RE: QuikTrip Store #4299 Final PUD Plan and QuikTrip 4299 Subdivision Filing No. 1 - Final Plat Applicant Responses

Thank you for the comments dated November 1, 2021 regarding the subject development application under Final PUD and Final Plat review. We appreciate you working with us to resolve the comments since their issuance; below is a summary in ***bold and italics*** of our responses that coincide with our related plan revisions.

BOUNDARY DETAIL  
SCALE: 1" = 60'

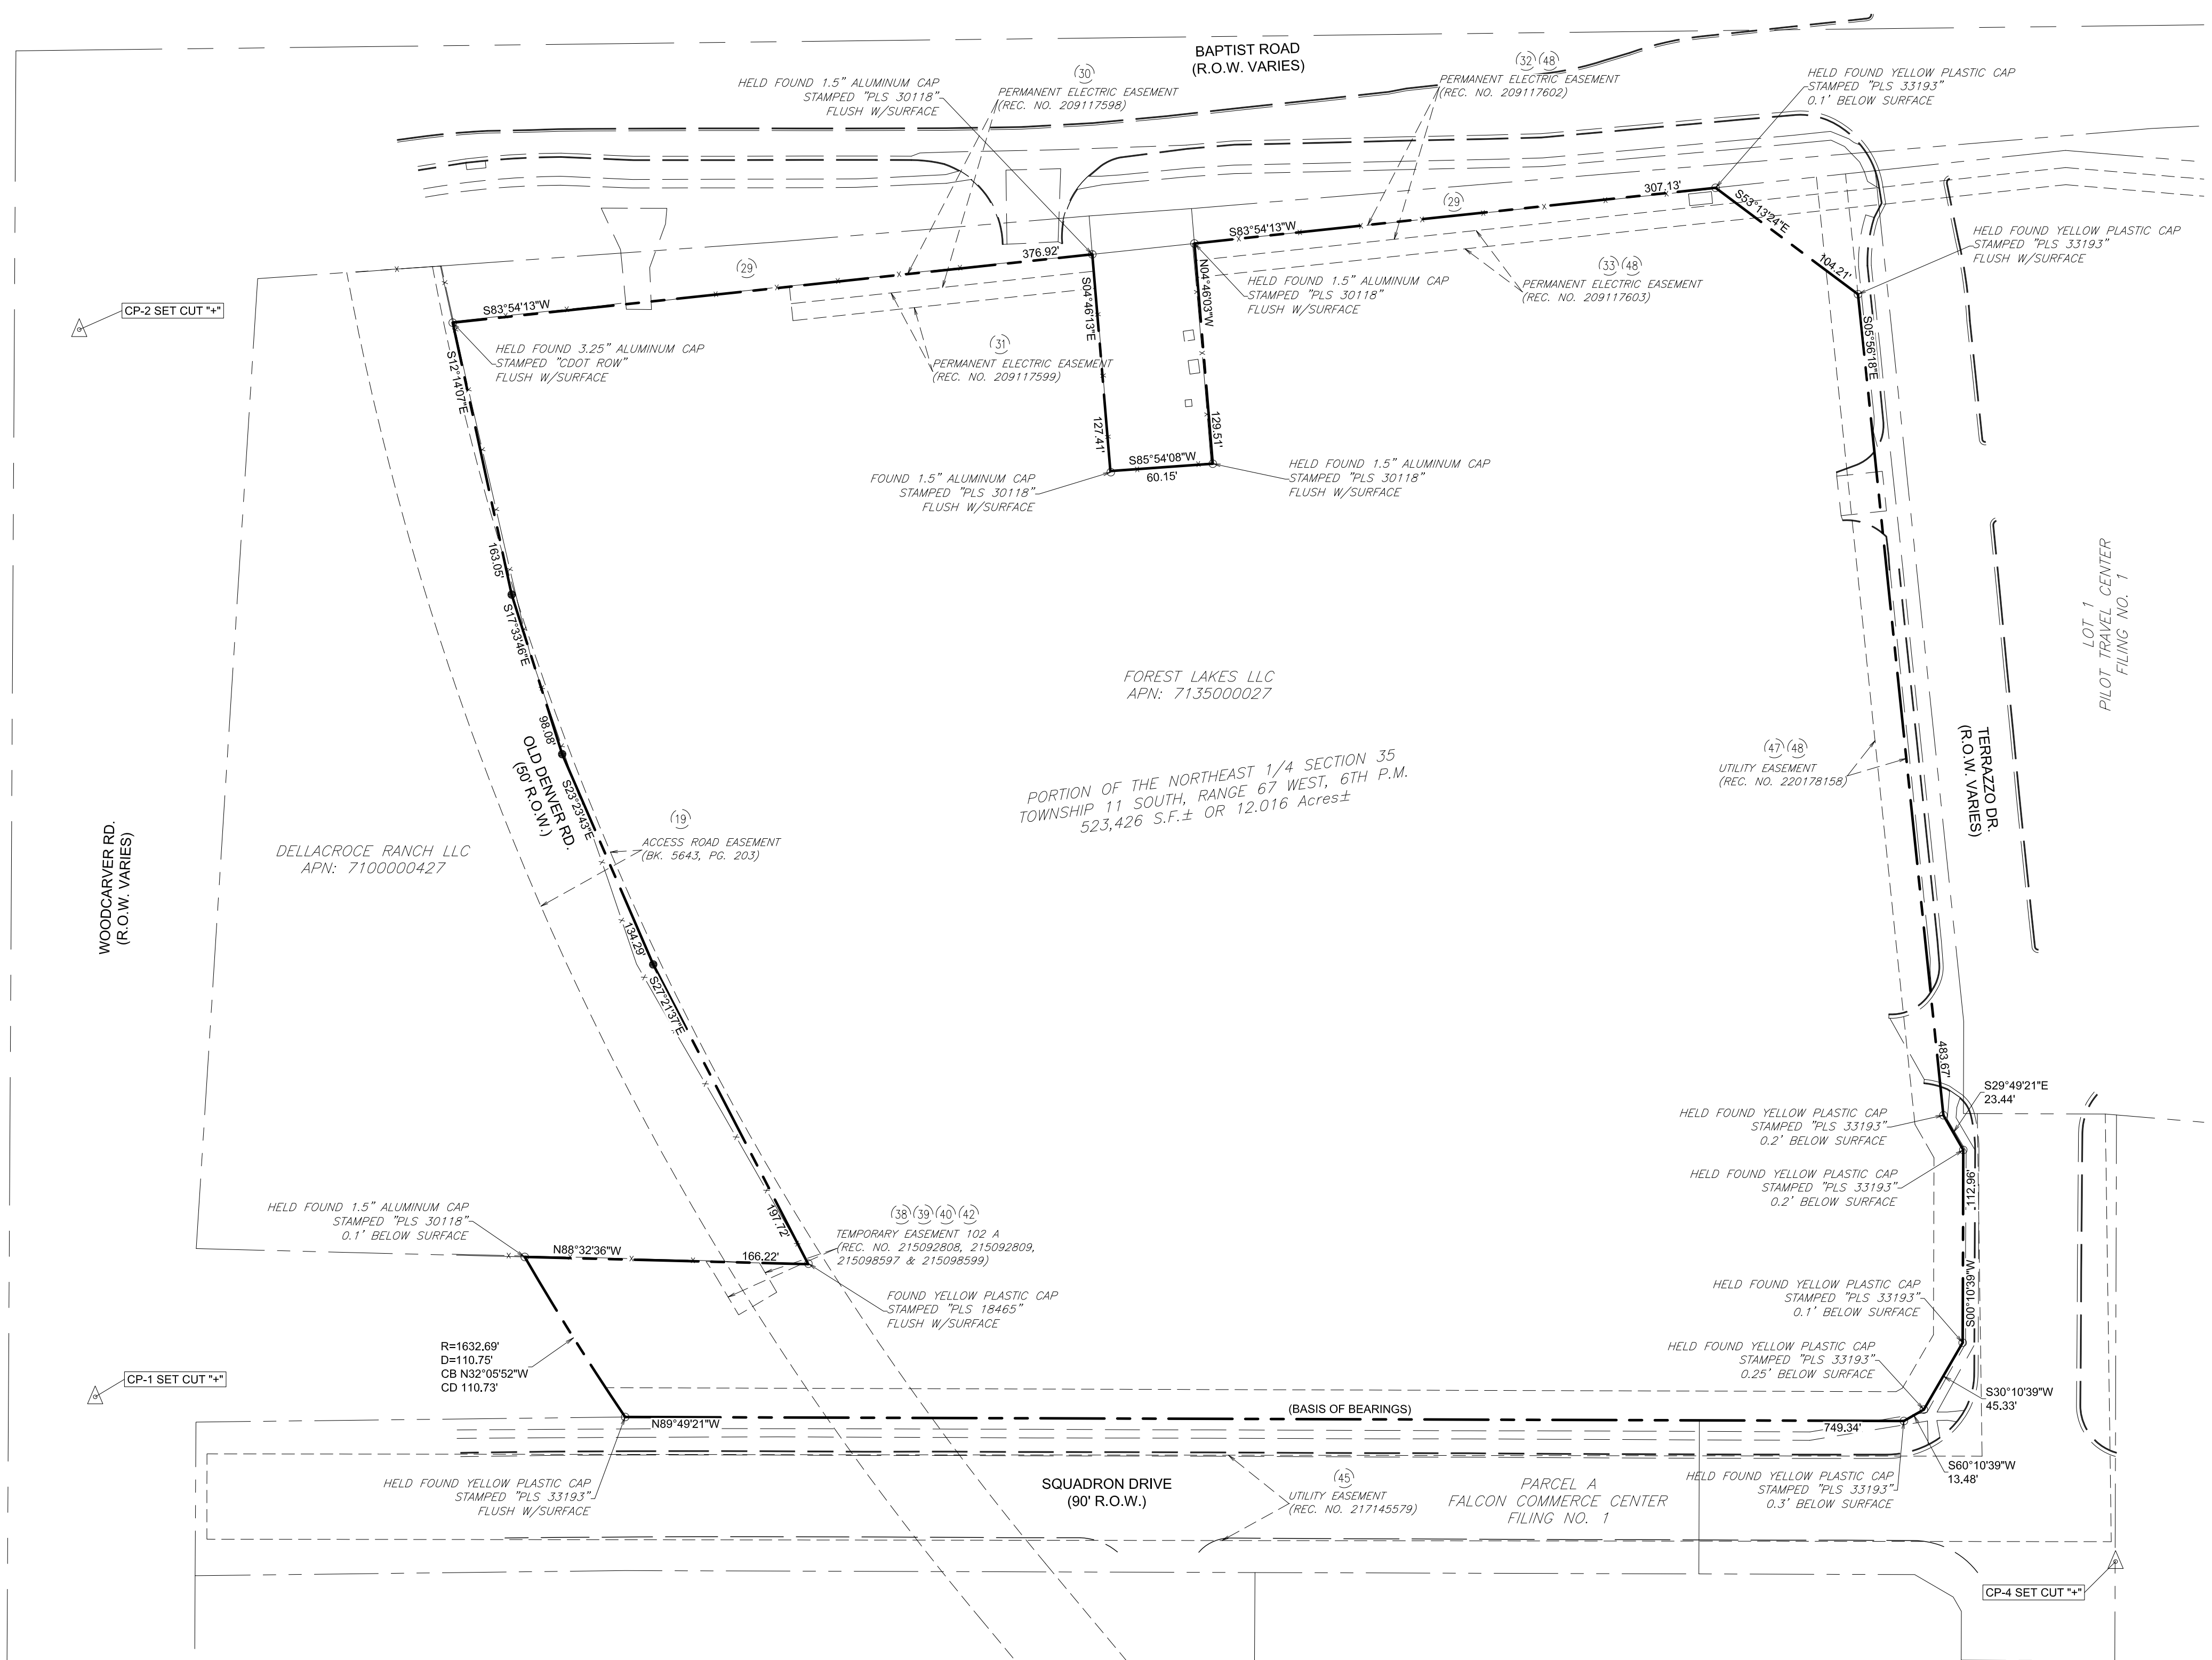
Topographic Survey Plan (Sheet 3):

11. No need for a legend on this sheet.

12. There is no need to show the previous Old Denver Road. It is an obsolete road.

Altura Response: This is an ALTA survey that was prepared for this project which must include the appropriate legends. No changes made.

Altura Response: The Old Denver Road has not been vacated, the County Assessor still shows it on the maps as a road and has references made to it from other legal descriptions. No changes made.

TOPOGRAPHIC SURVEY PLAN

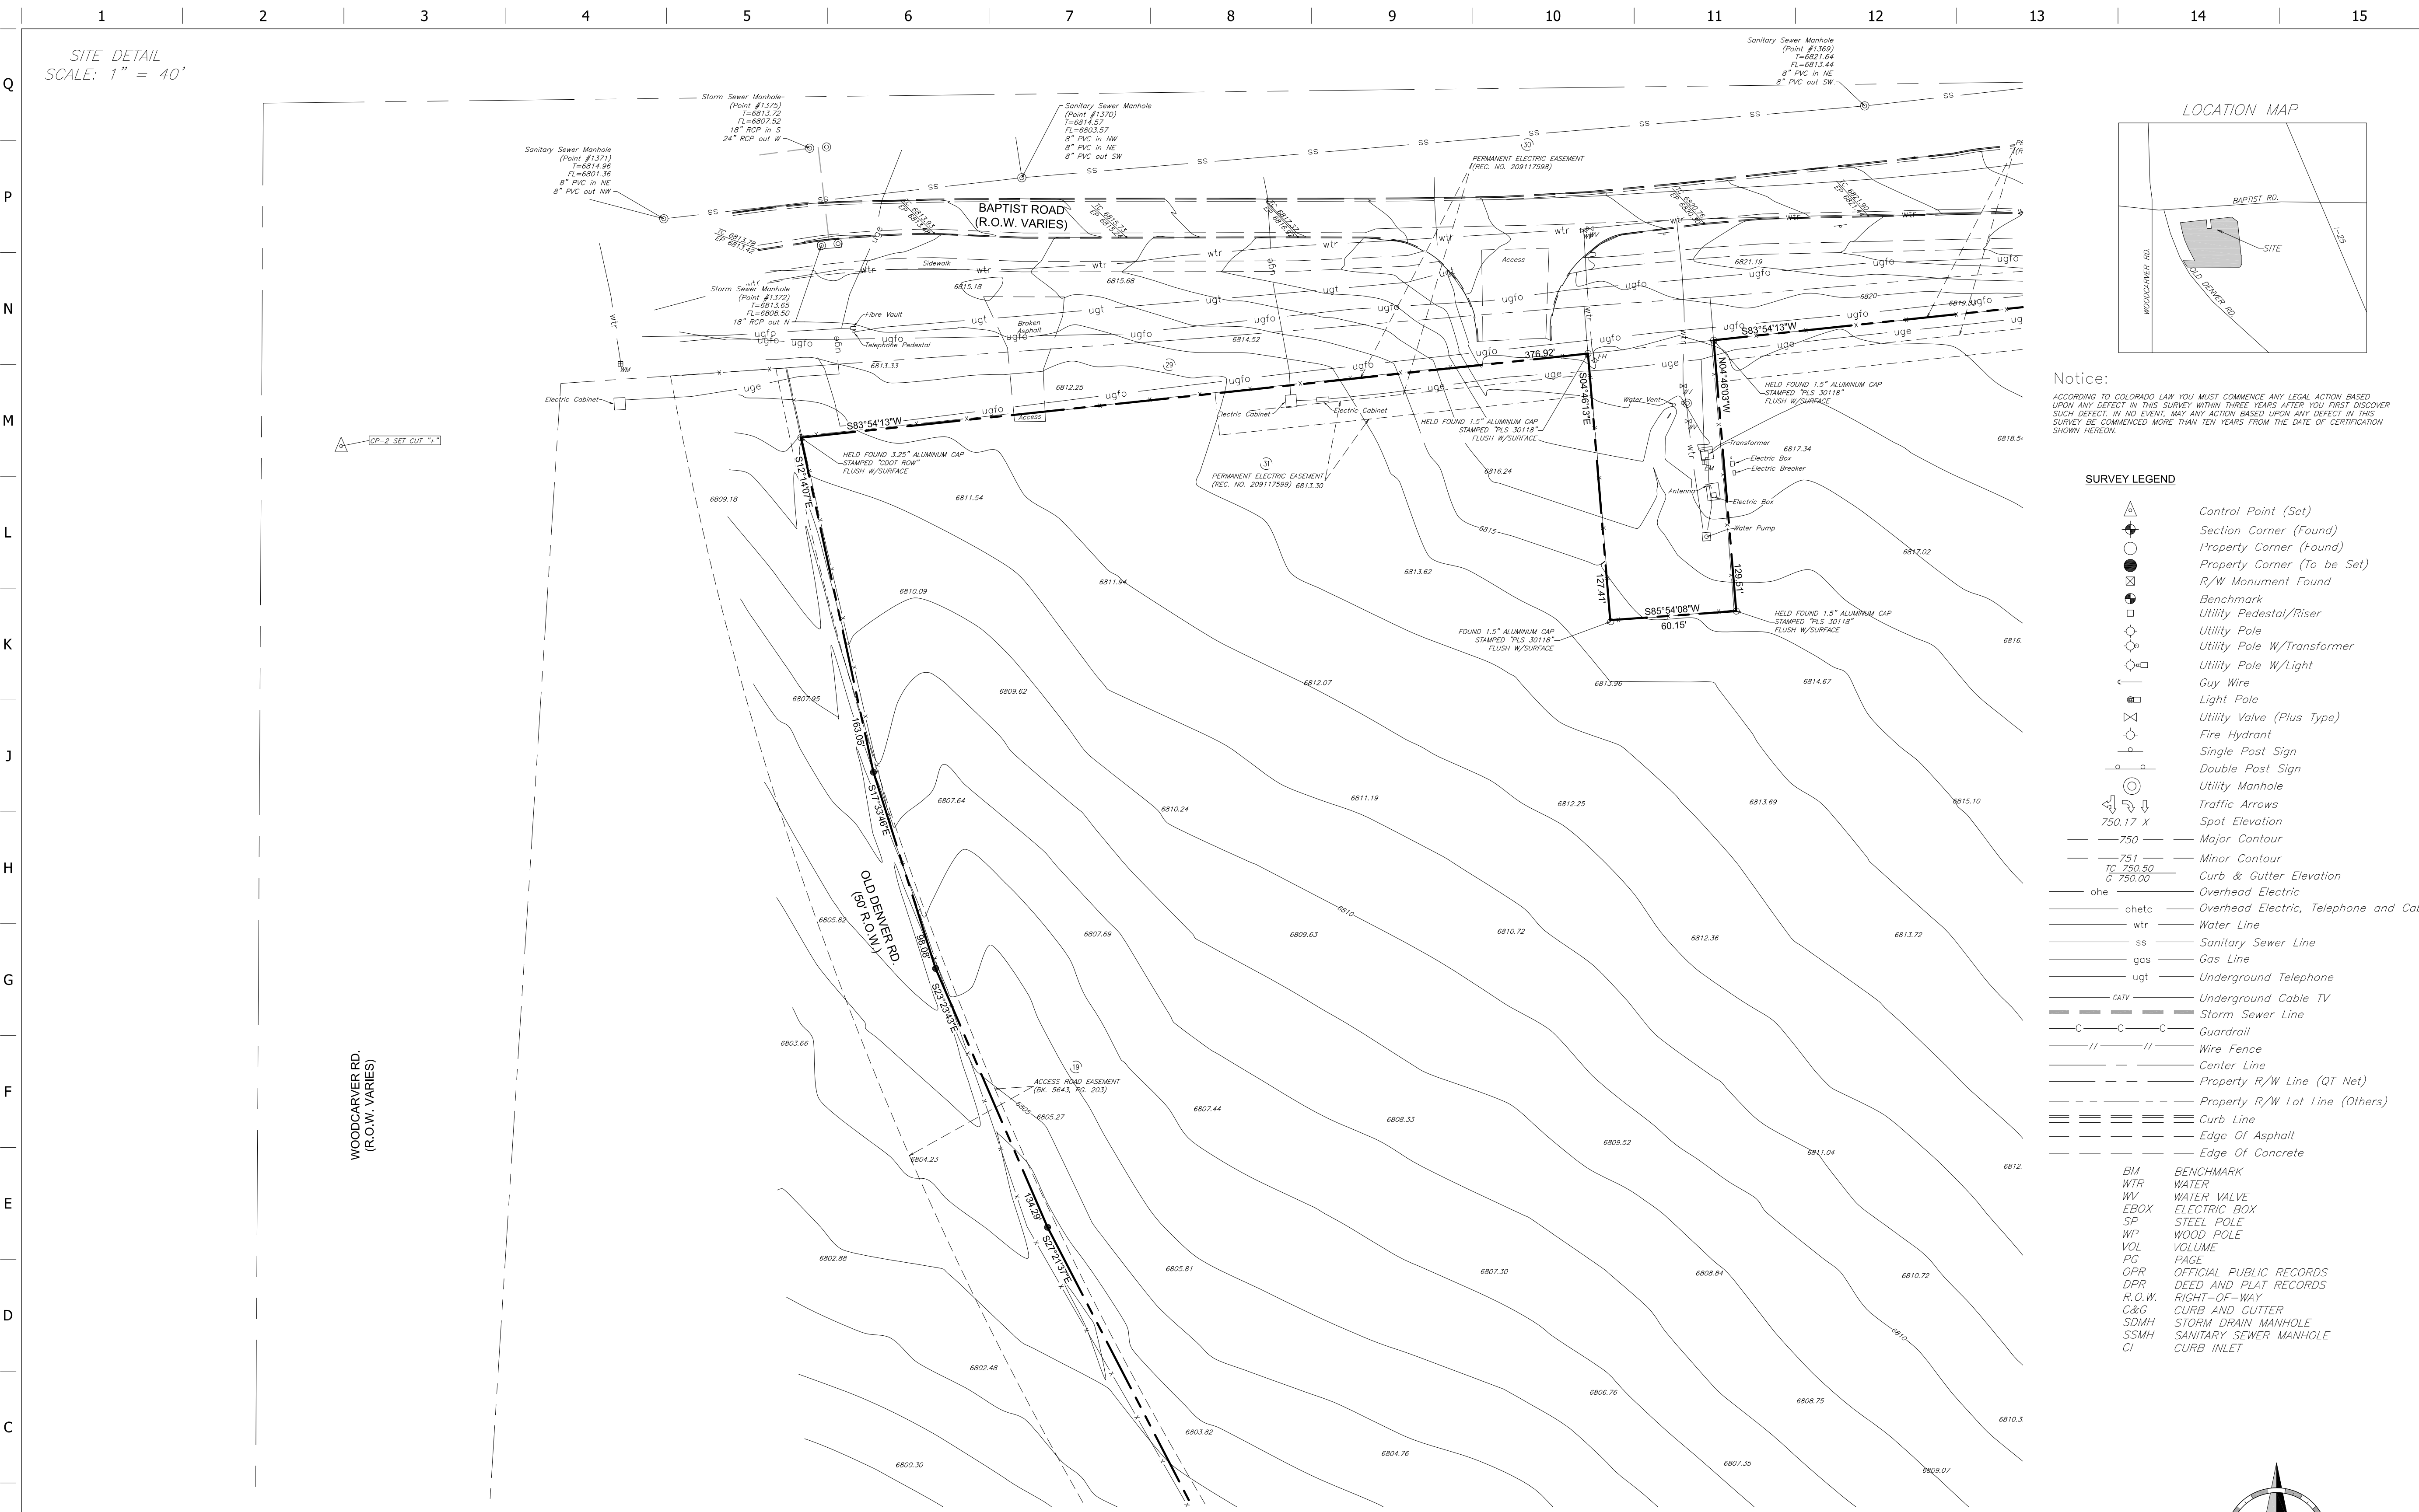
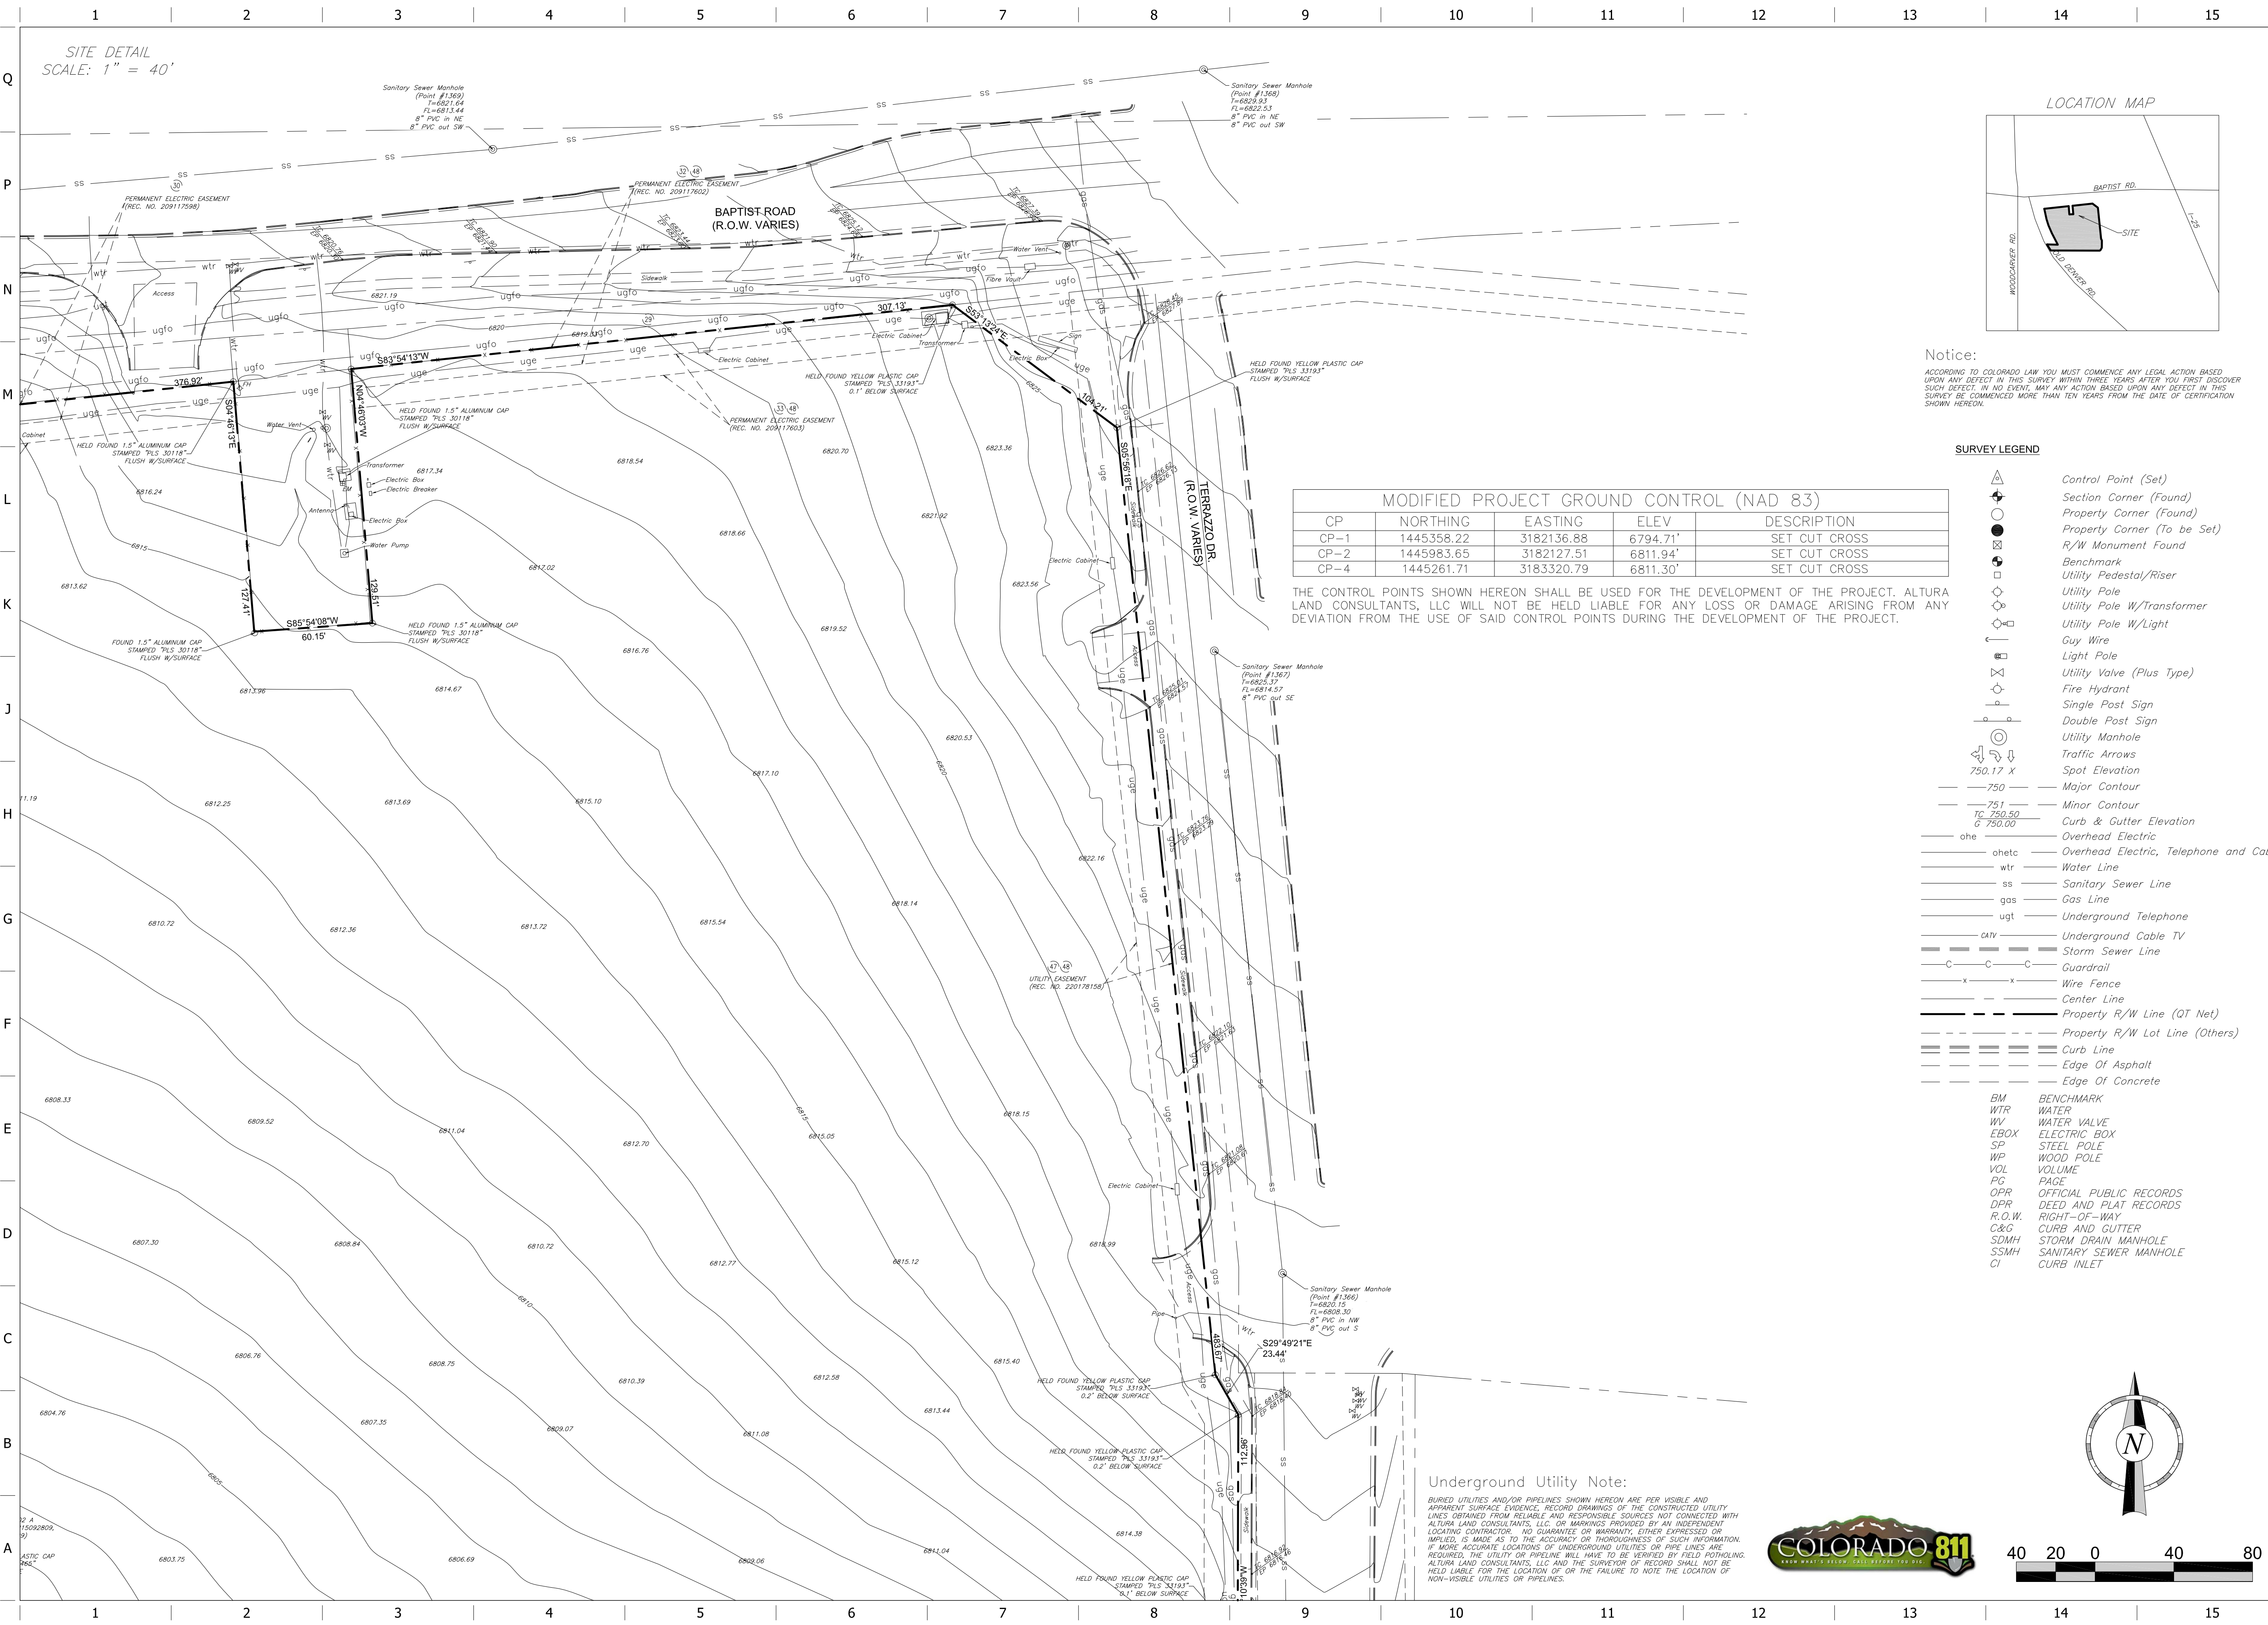
Topographic Survey Plan (Sheets 4, 5, 6, 7, and 8):

13. Only use the legend symbols if shown.

14. There is no need to show the previous Old Denver Road. It is an obsolete road.

15. Please call out Squadron Drive.

Altura Response: This is an ALTA survey that was prepared for this project which must include the appropriate legends. No changes made.

Altura Response: The Old Denver Road has not been vacated, the County Assessor still shows it on the maps as a road and has references made to it from other legal descriptions. No changes made.

Altura Response: Squadron Drive has now been called out.
